Recommendation Report for Planning Permission for Works or Extension to a Dwelling

REF NO: BE/40/21/HH

LOCATION: 7 Cygnet Walk
Bersted
PO22 9LY

PROPOSAL: Two storey side extension and rear single storey extension.

PROPOSED FIRST FLOOR PLAN

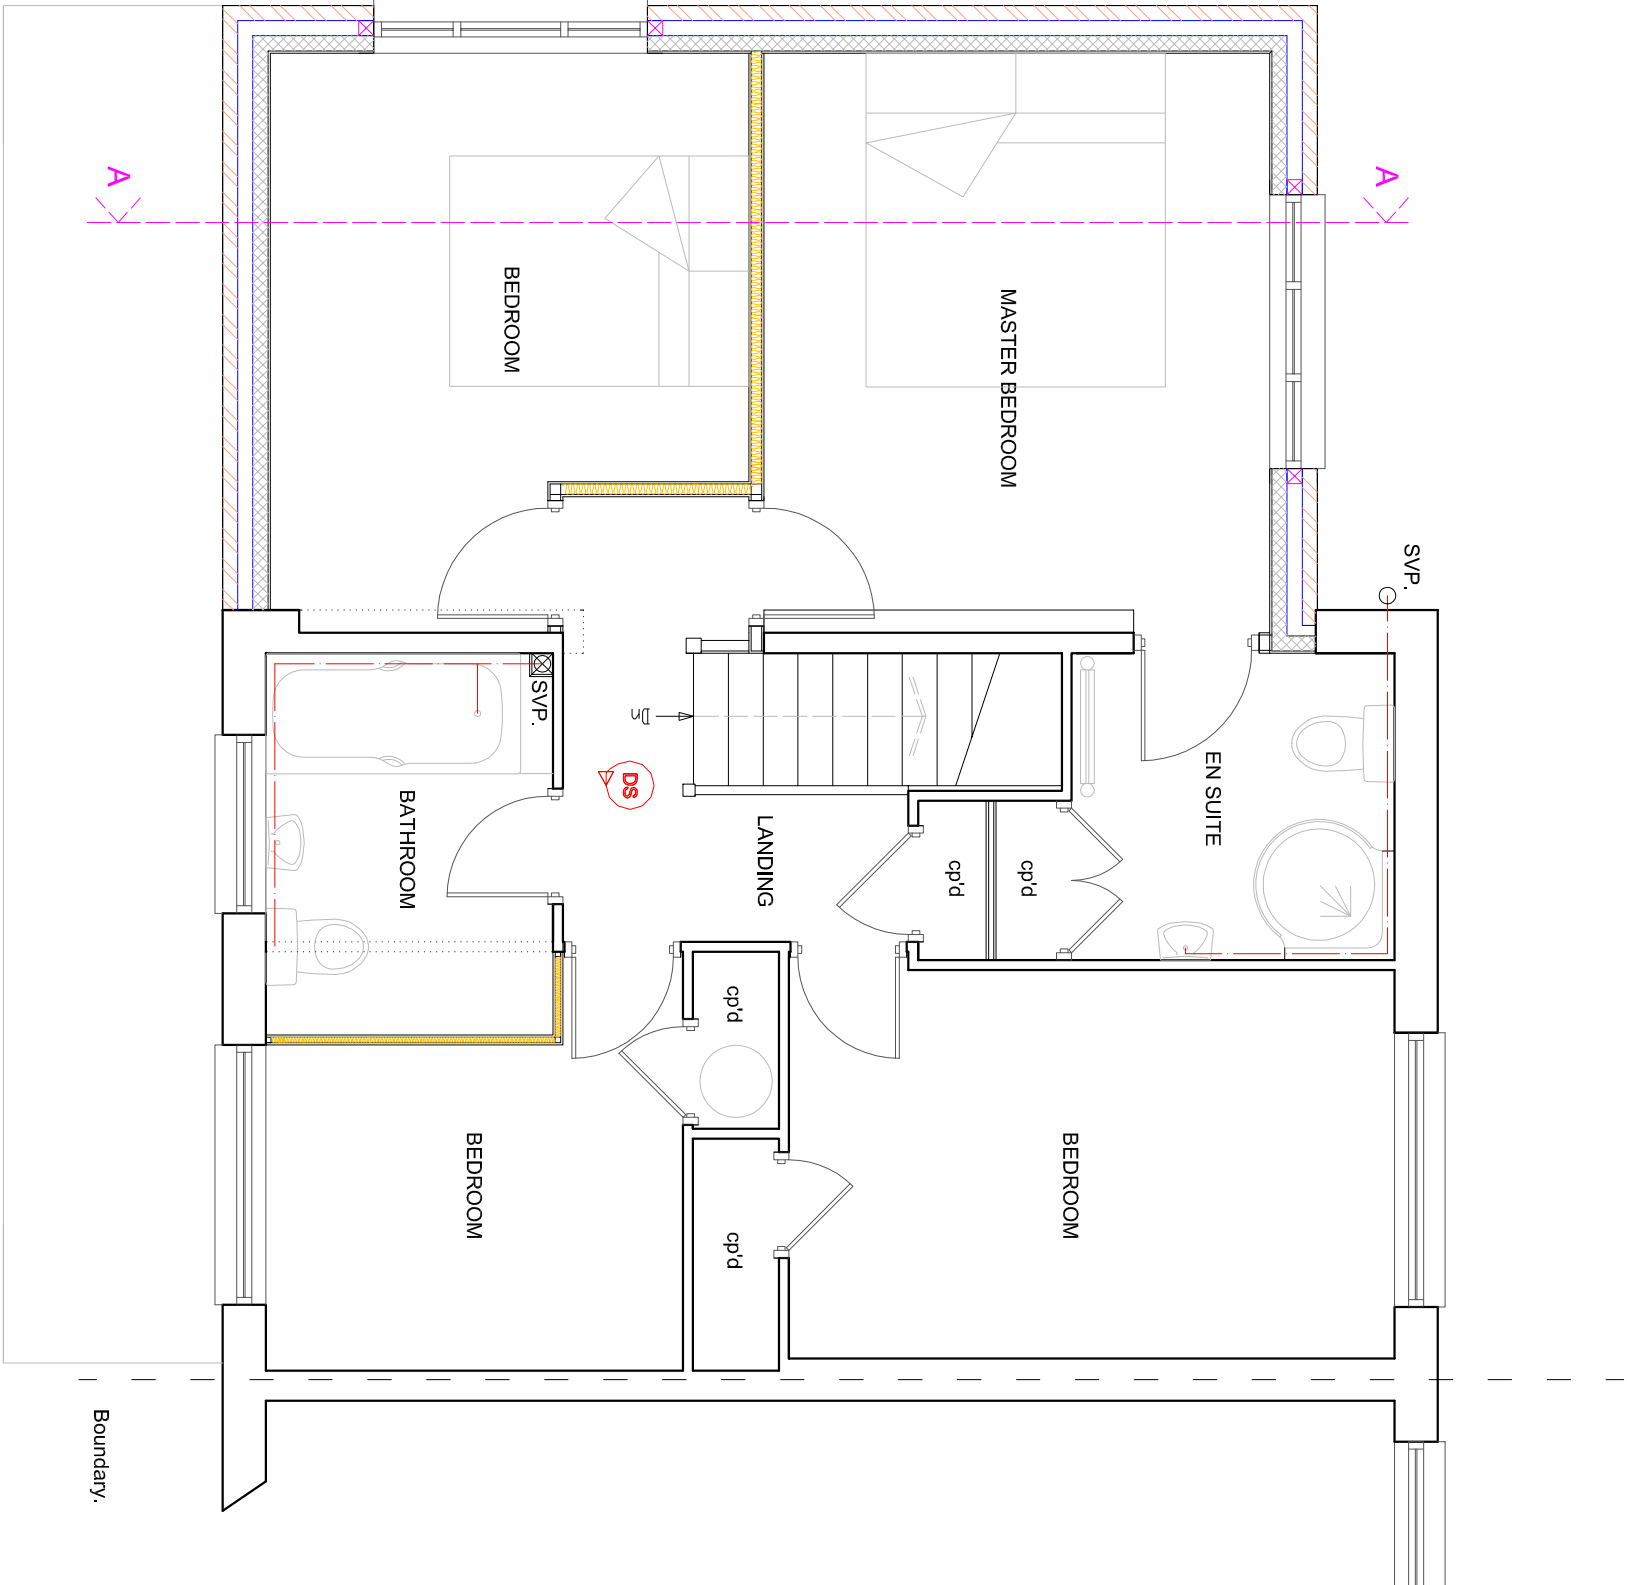
The proposals will be sited on the north elevation and infill the north side of property to rear elevation. The two storey side extension will a width of approximately 8.69m and a depth of approximately 3.99m. The height will be approximately 7.26m to the pitched roof ridge line. Due to no direct neighbours to north and east due to location of the road, there is no harm to overlooking to neighbouring properties to north and east. The proposal will cause some minor overshadowing to the neighbouring property at number 9 to rear however due to the large gap of 6.67m remaining to rear boundary it is not deemed to cause adverse harm to overshadowing or overbearing effects so will comply with policy D DM4 of the Arun Local Plan.

PROPOSED ELEVATIONS

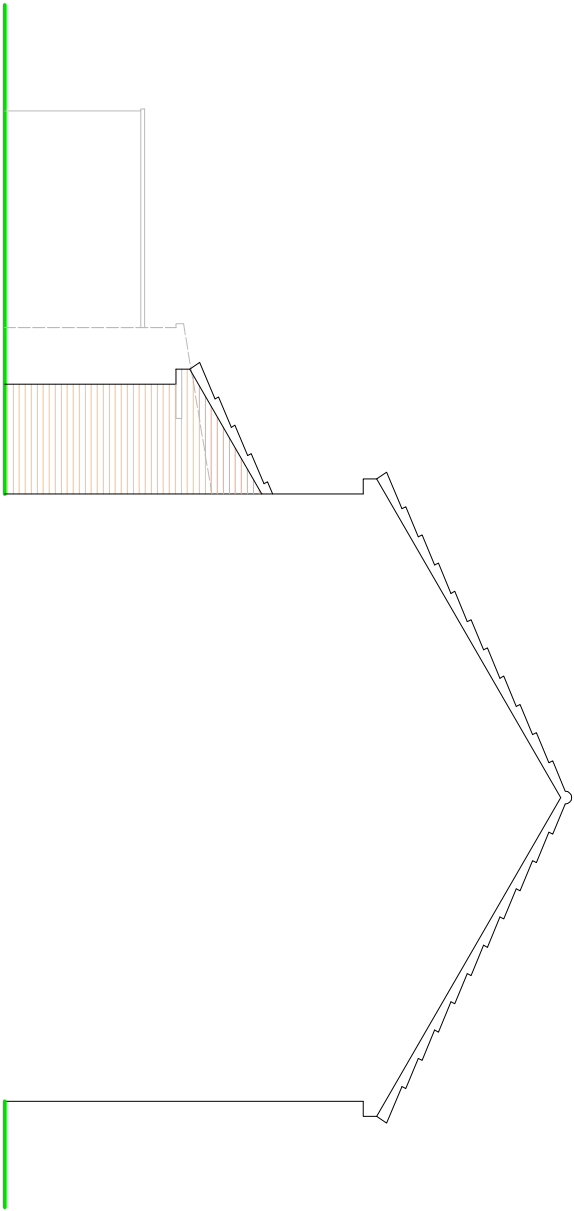
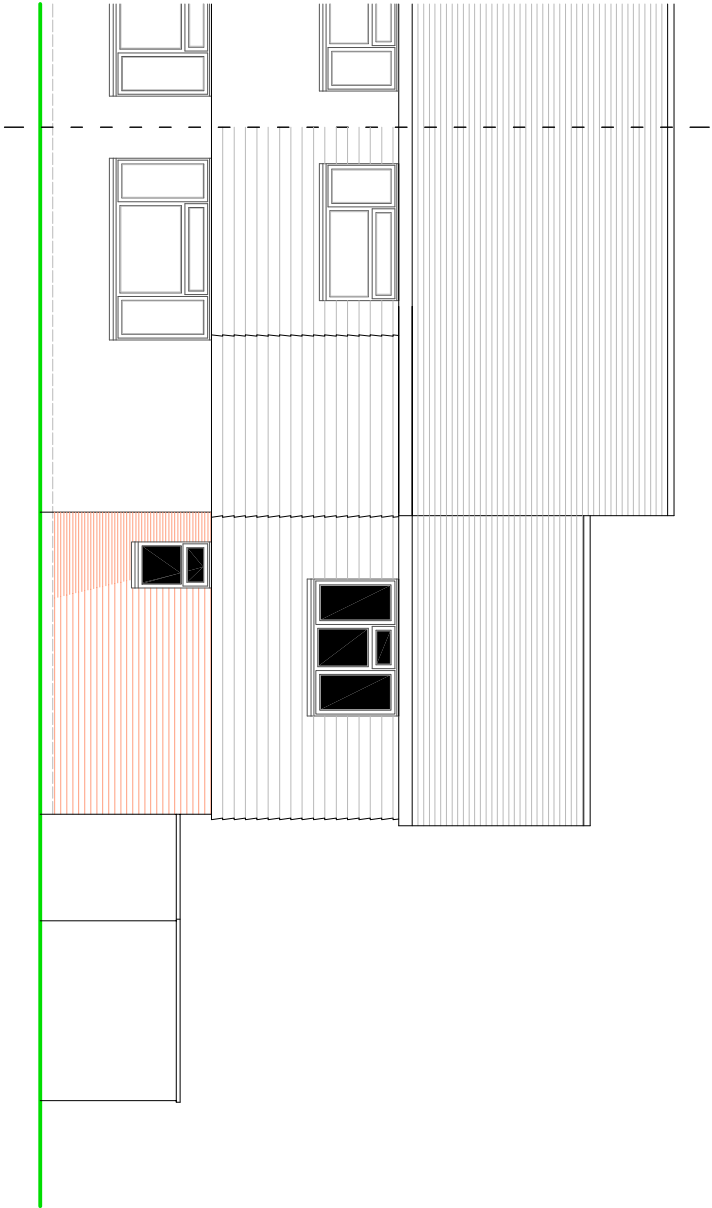
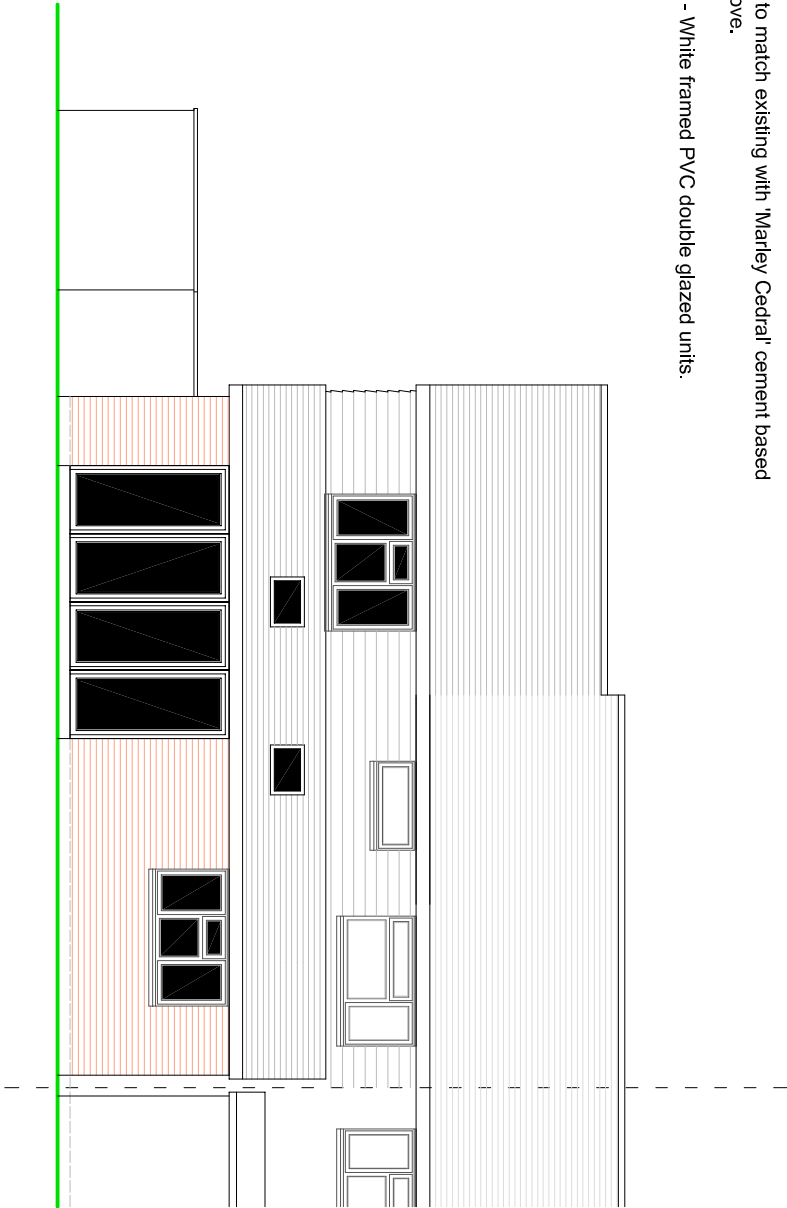
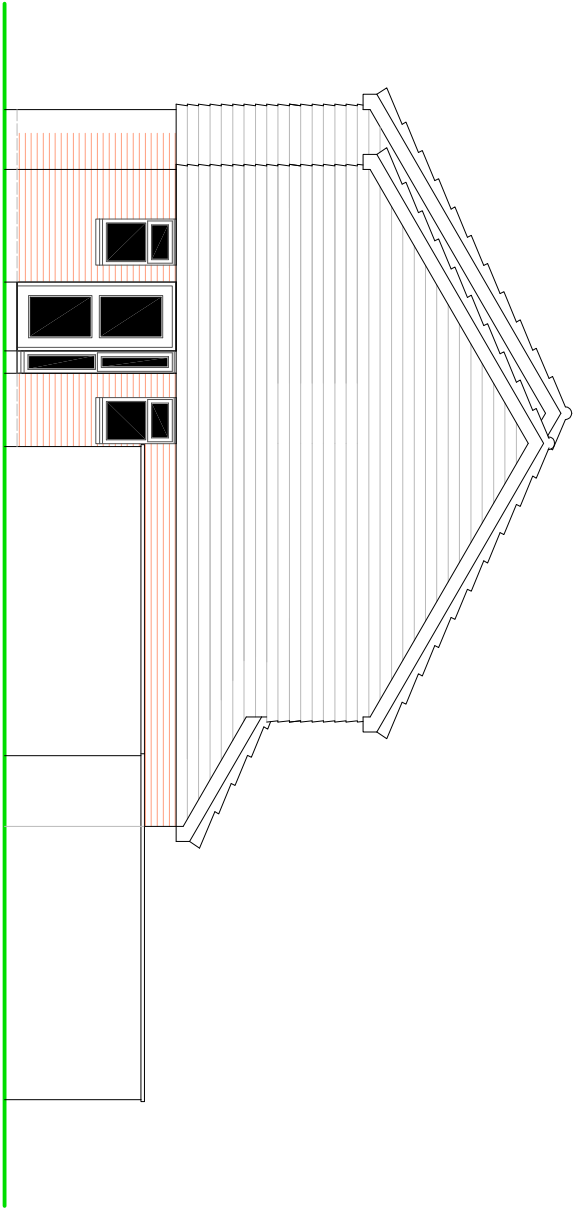
The two storey side extension will a width of approximately 8.69m and a depth of approximately 3.99m. The height will be approximately 7.26m to the pitched roof ridge line. The pitched roof design is in-keeping with property and seems to visually integrate with surrounding area. The extension will be sited further back behind the principal east elevation to front so this will comply and it is in line with the rear elevation of dwelling to west. The proposal will have a single window at ground level and a triple window at first floor facing east. There is also a triple window at first floor rear facing west. There will be a new door on north side elevation and two new windows facing north.

The rear single storey extension will have a width of approximately 8.93m and a depth of approximately 1.47m. The height will be approximately 3.55m to pitched roof and 1.92m to flat roof. The roof design is in-keeping with existing property and being at single storey it is deemed acceptable. The proposal will have restricted views from the street scene due to existing boundary wall remaining to north and the two storey addition to north east. The proposal will include 2 new roof lights in the flat roof section. There will be new bi-fold double doors on west elevation facing rear garden and triple windows facing west to rear garden.

The materials will match existing and consist of face brick walls, concrete interlocking roof tiles on pitched roof section, white PVC doubled glazed windows and doors so will comply with policy D DM1 and D DM4 of the Arun Local Plan.

PROPOSED GROUND FLOOR PLAN

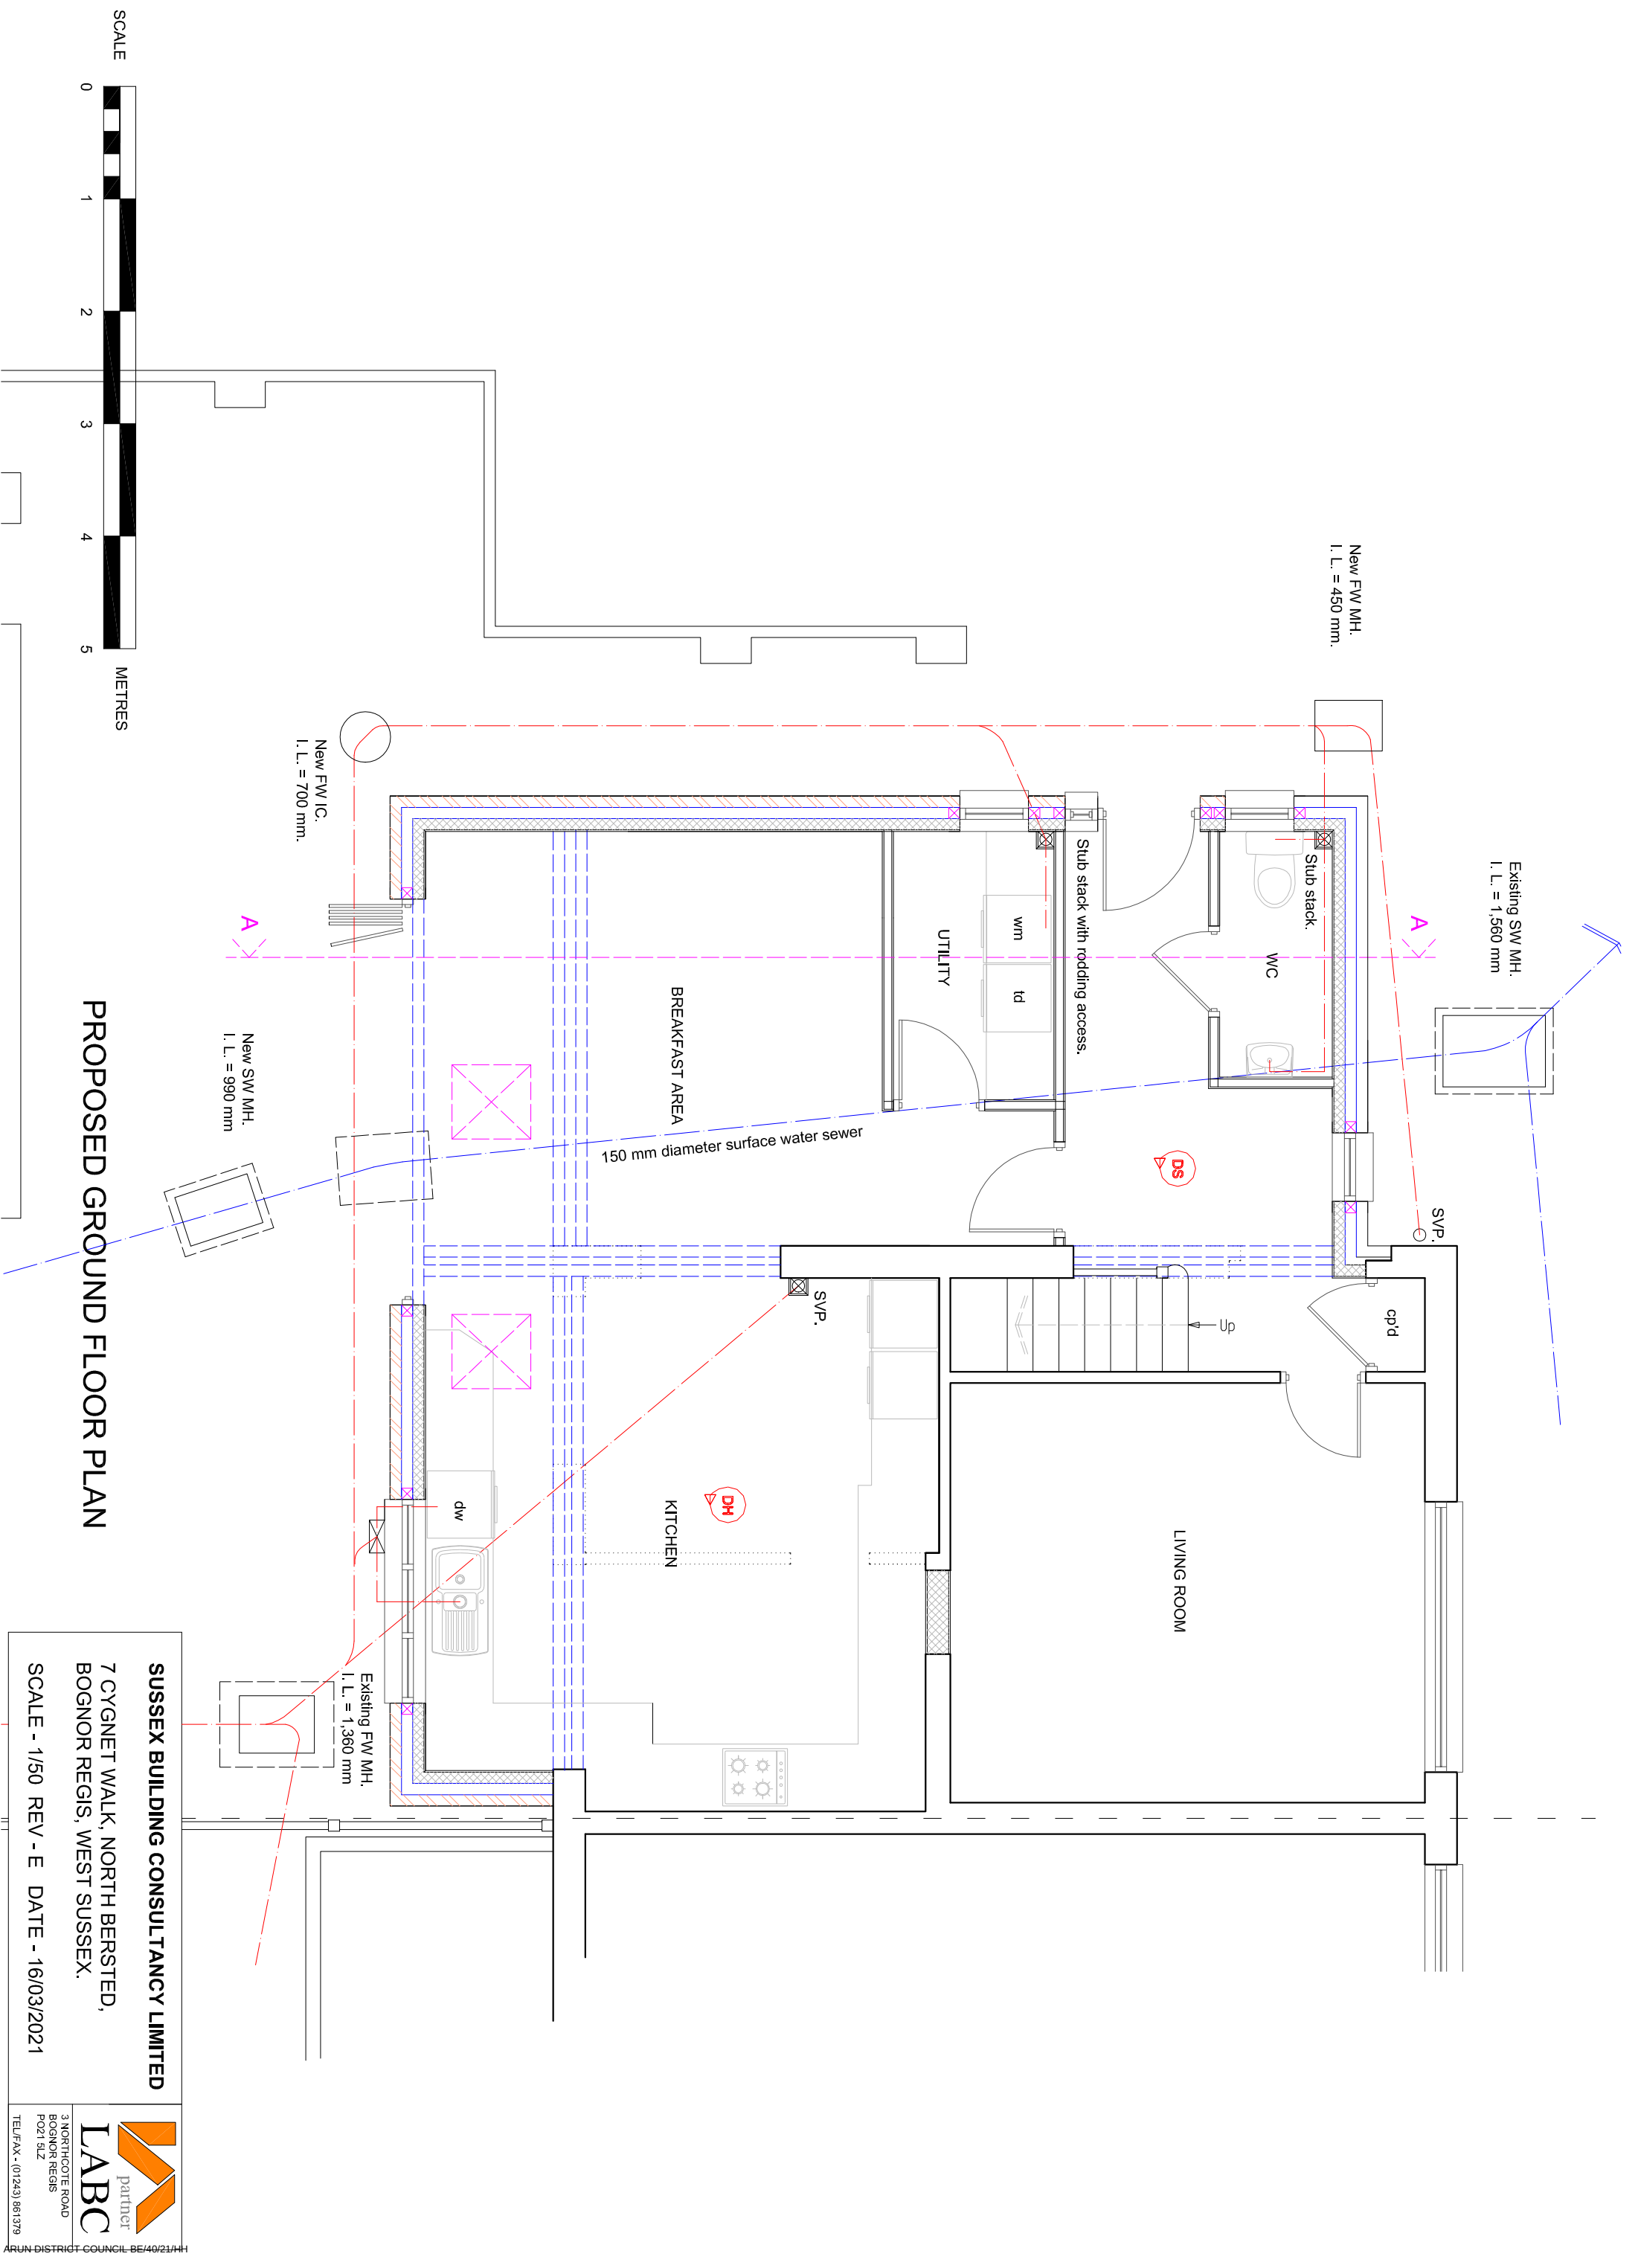
Whilst the rear single storey extension being within 1m of the south side boundary does not comply, it is at single storey and there is a gap remaining on the north side of property so is deemed acceptable. Also there will be no harm to overlooking to neighbouring property to south as there are no windows proposed in the south, it will not have adverse overlooking impact on neighbouring property to south.
